**Jalco Manufacturing Facility (SSD-21190804)
Request for additional information**

I refer to the Response to Submissions (RtS) for the Jalco Manufacturing Facility (SSD-21190804).

Attachment 1: Department's request for additional information

Figure 8.6 Containment Areas

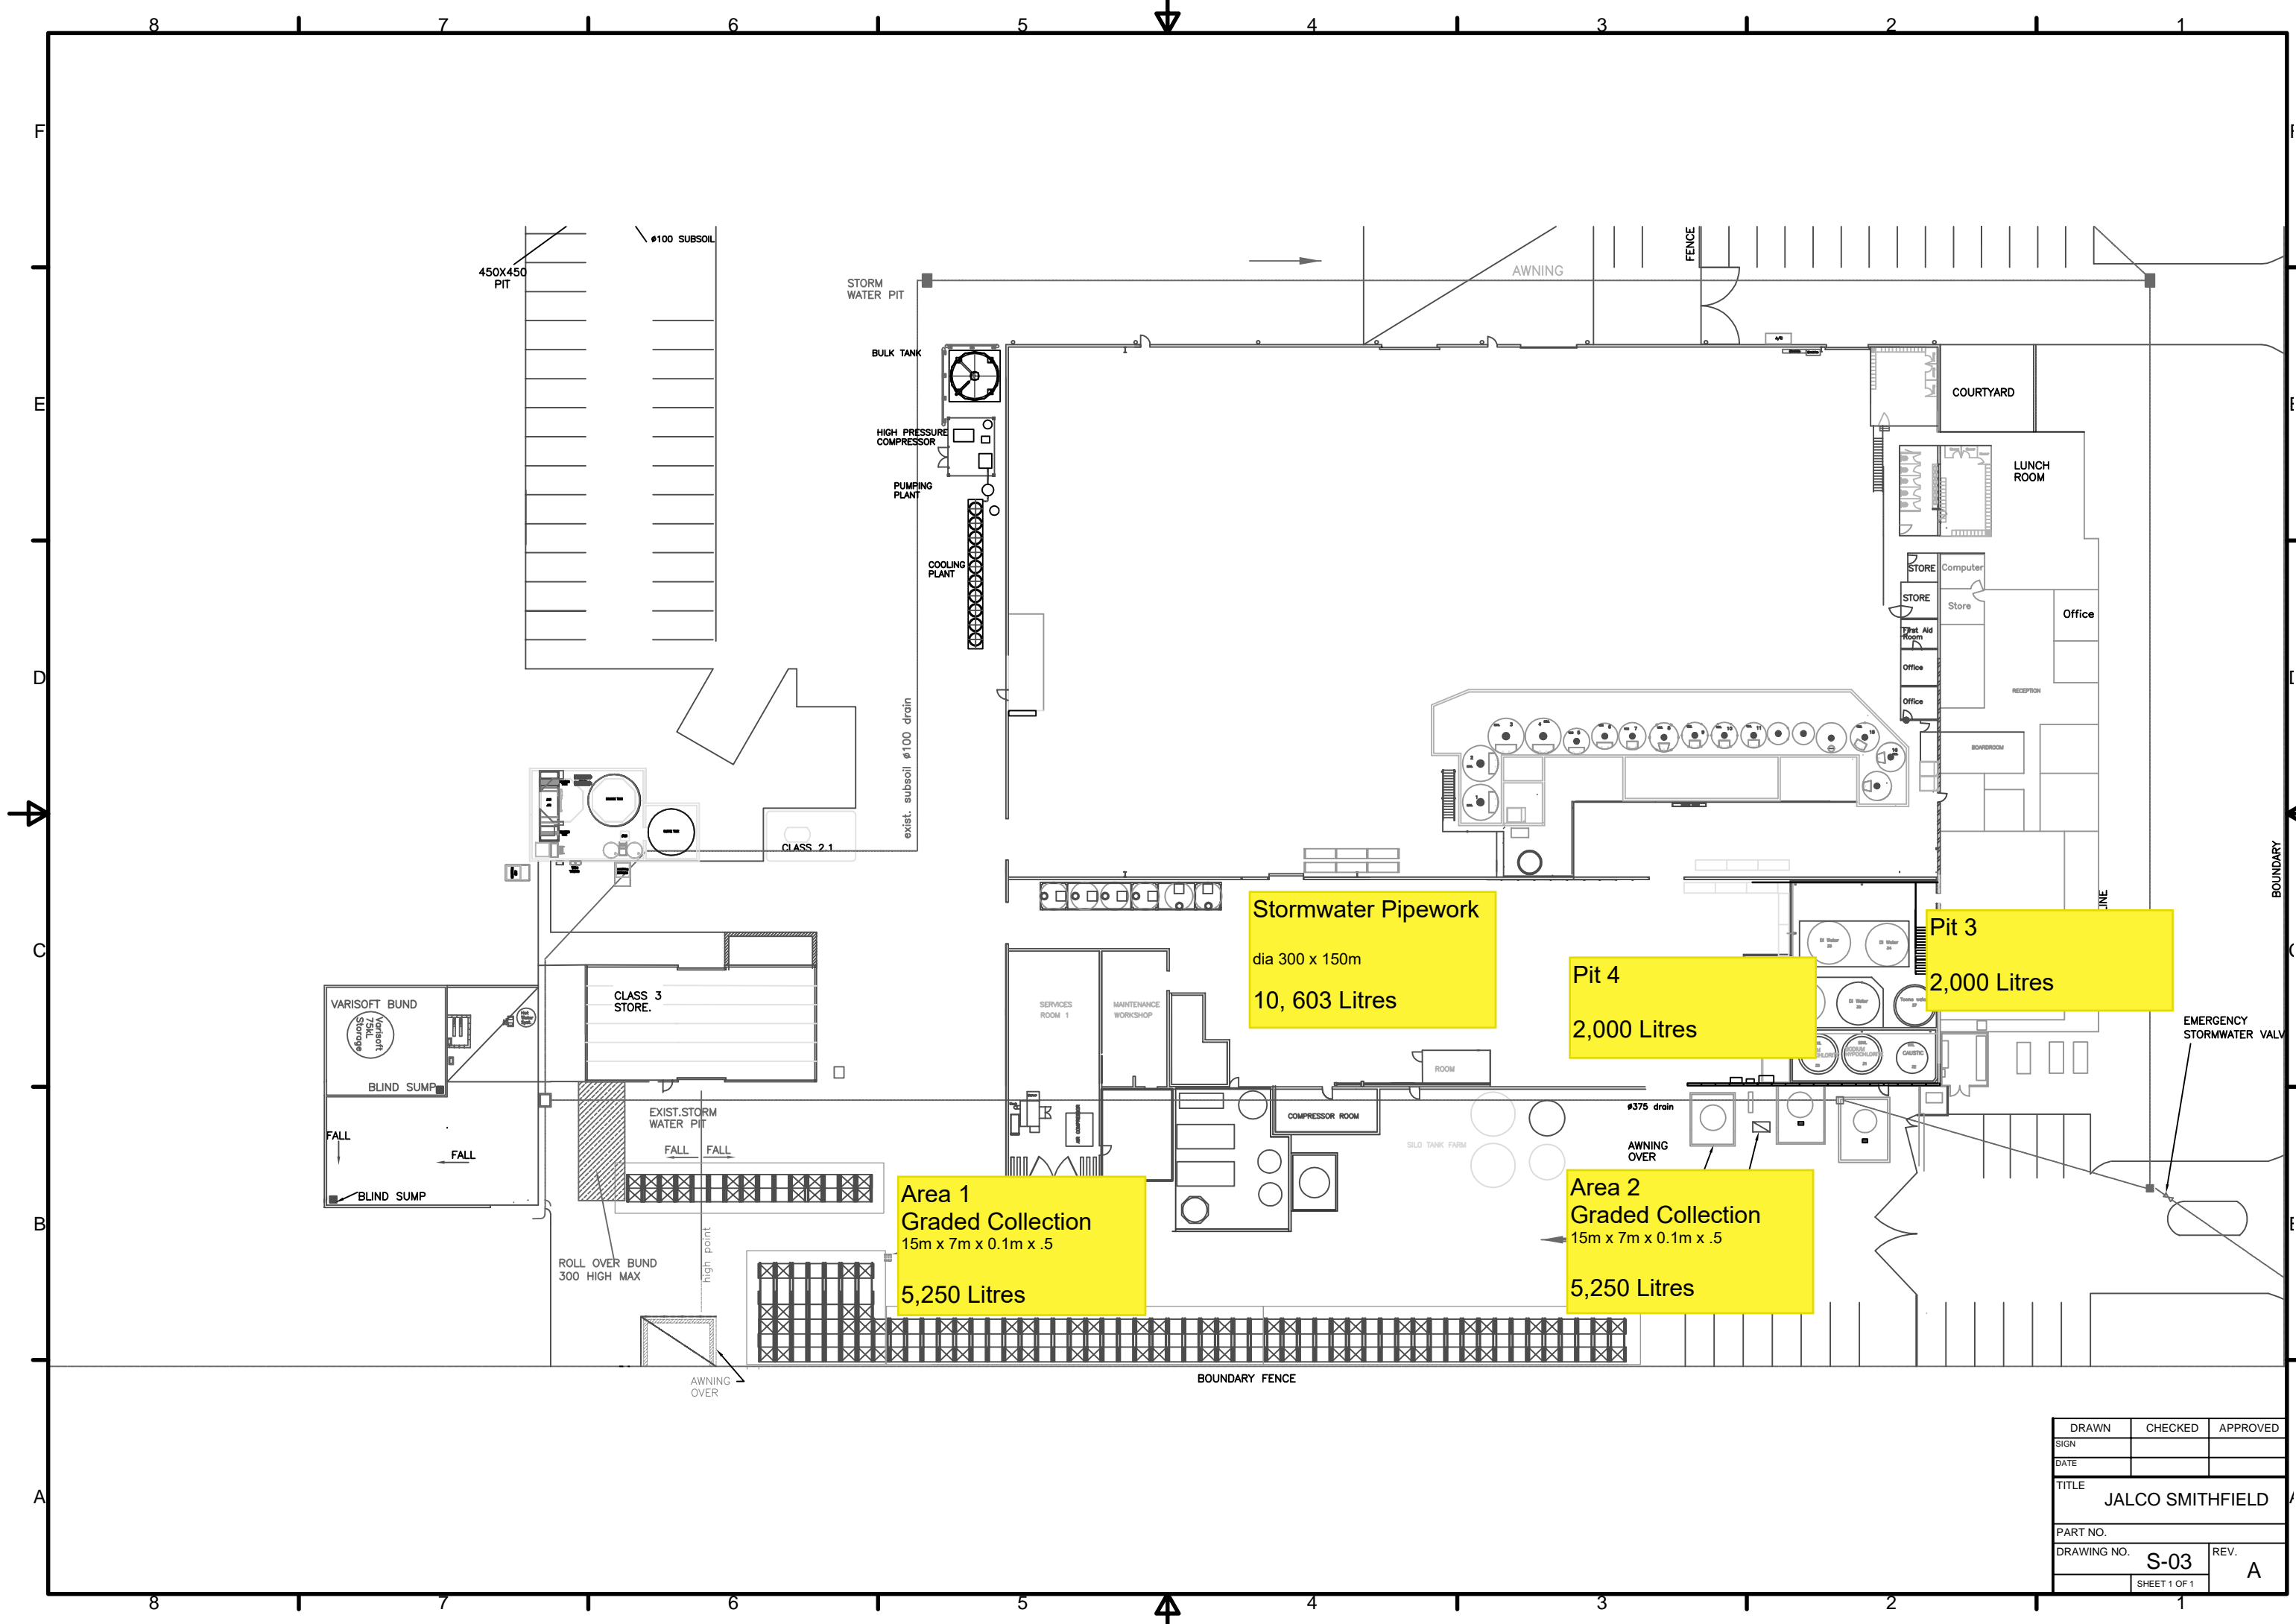
- The external potentially contaminated hardstand areas should be separated from the clean stormwater areas similar to the Smithfield facility as described in the Contaminated Water Retention Plan (Appendix P of the EIS). Please provide details of the contaminated water retention system isolated from the stormwater system.
